**Date:** October 18, 2022  
**To:** Jeremy Cromie, County Planner II  
**From:** Craig Jones, City Development Coordinator *CJ*  
**Through:** Derek Mayo, City Engineer *DKM*  
**Re:** Calvary Church Expansion – RU-22-00003

The following are the City Public Works comments on the Reasonable Use for the proposed Calvary Church Expansion at Vantage Hwy and Cowboy Ln.

CITY OF ELLENSBURG PUBLIC WORKS DEPARTMENT UTILITY MAP REQUEST INFORMATION

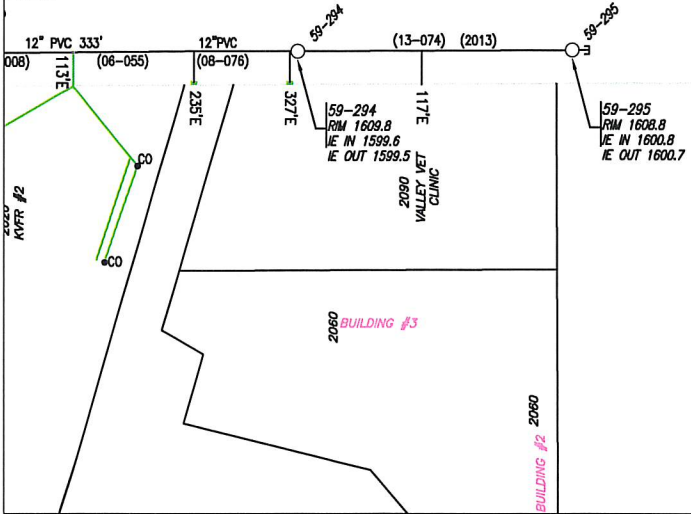
The water main available to serve this development is a 12" Ductile Iron main that runs in Vantage Hwy and stops approximately 680'+/- from the proposed project. The developer will need to extend the main to the farthest east extents of the property being developed along Vantage Hwy. The existing buildings on site will need to connect to City water. See attached utility map.

The sewer main available to serve this development is a 12" PVC main that runs in Vantage Hwy and stops the same location as water. The developer will need to extend the sewer main to the farthest east extents of the property being developed. The existing buildings on site are served by an onsite septic system that will need to be abandoned and connected to City. See attached utility map.

There is a drainage ditch along the south side of the parcel. Stormwater outfall could be discharged here after on site treatment and flow control were met. See attached utility map.
